OUT18/6591

Gunnedah Solar Farm (SSD 8658)
Comment on the Environmental Impact Statement

Orange Grove Road, Gunnedah
1% AEP Flood Depth
Existing Scenario

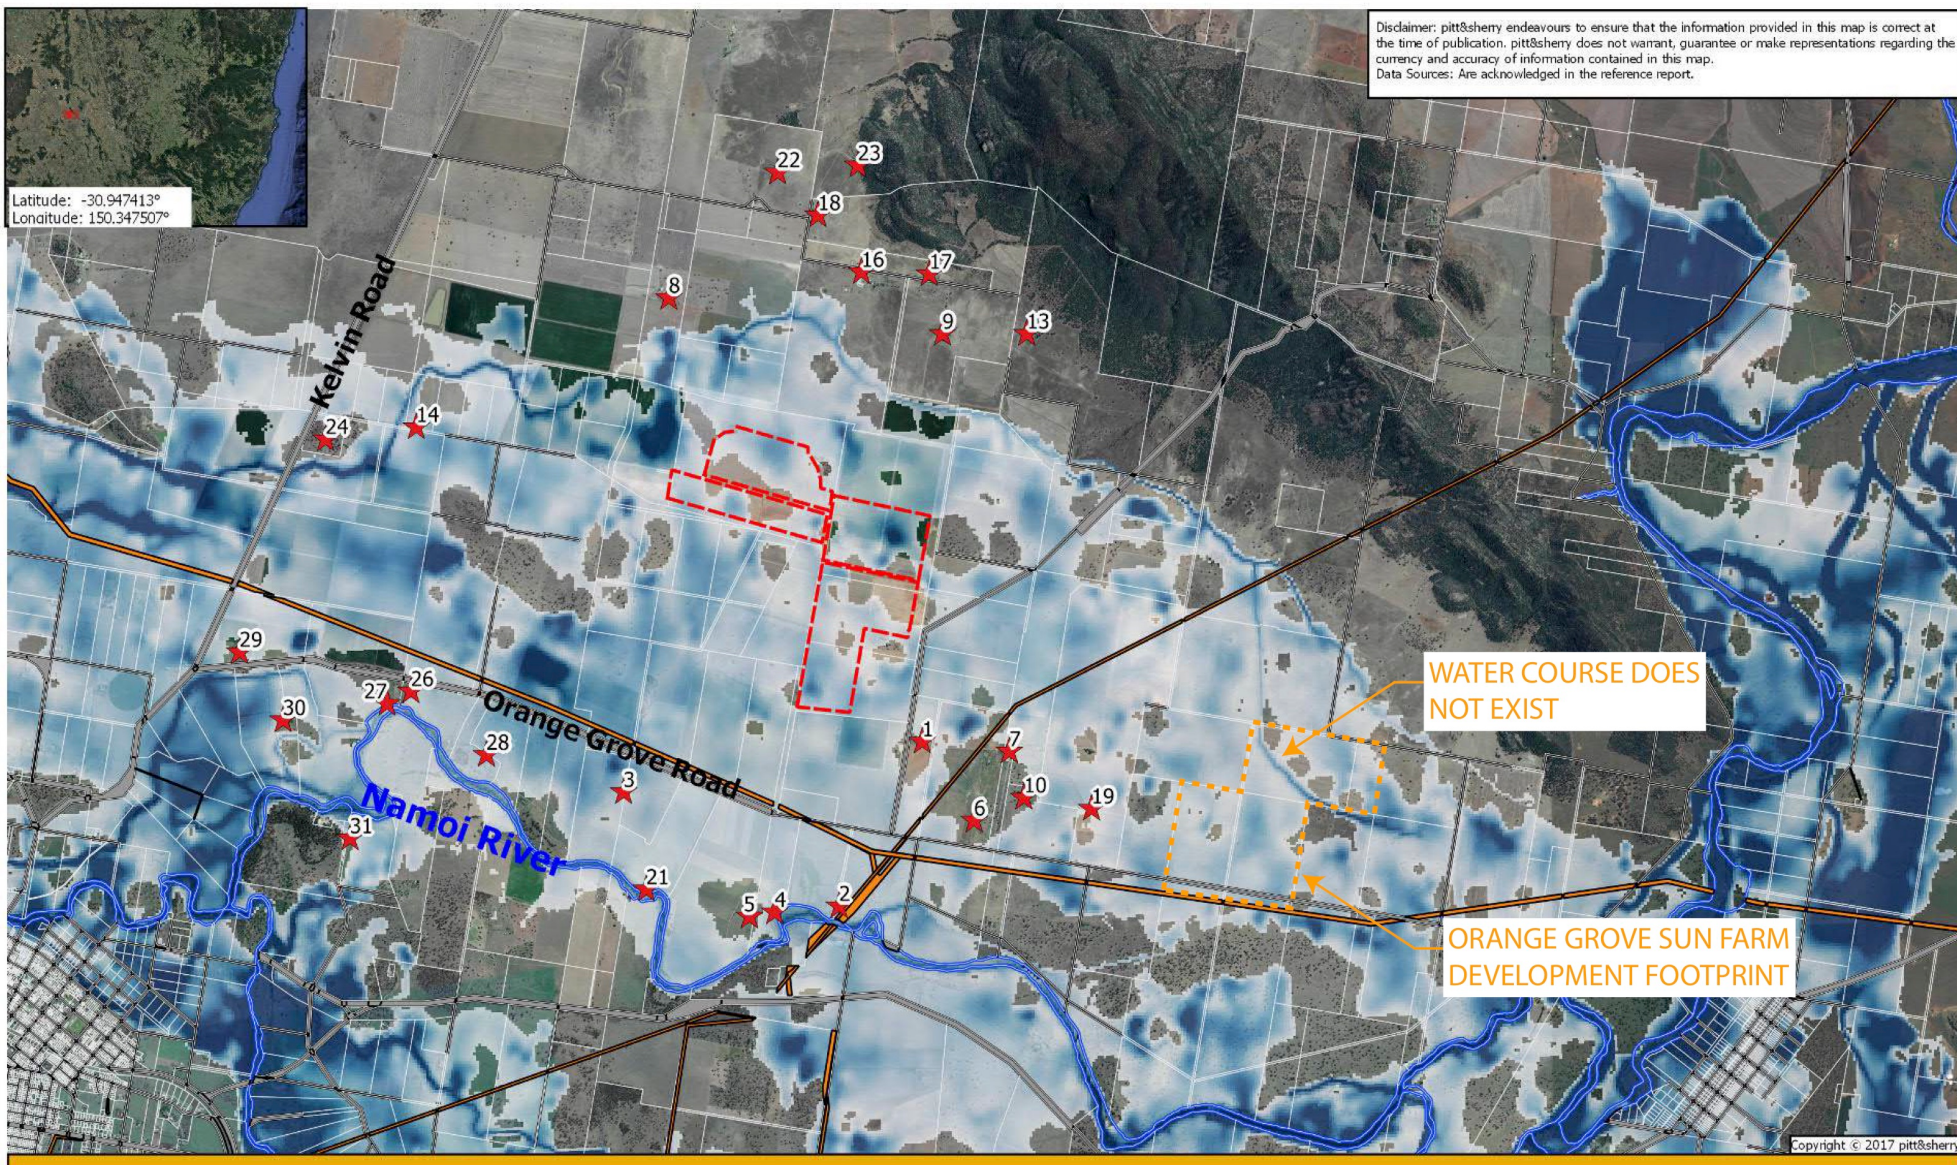
- Interpretation of the 1% AEP Flood velocity existing scenario map and configuration 3 scenario map indicates an increase in flood velocity along the western side of the solar farm. The EIS states within laneways around solar panel infrastructure there is an increase in velocity from 1.5 m/s to 3.3 m/s where they overtop and cross over the fence. This is more than a maximum of 50% increase for velocities as per the complying works criteria stated in the Carroll to Boggabri Floodplain Management Plan (FMP). Further modelling is recommended around flood velocities and/or infrastructure modification to ensure that the proposal aligns with the complying works criteria under the FMP, including ensuring the predicted increased flood levels on adjacent landholders properties is less than 100mm and that drainage is to be within 24 hours of natural/existing drainage time.

- The proponent should revise the Land Use Conflict Risk Assessment (LUCRA) to consider potential impacts from surrounding land use on solar farm operations.
- Additional flood modelling should be provided which includes the inputs of both the Mooki River and the Namoi River to ensure impacts are consistent with the requirements of the Carroll to Boggabri Floodplain Management Plan (FMP), including ensuring the maximum increase in velocity is within the criteria of the FMP. This may require modifications to the infrastructure.
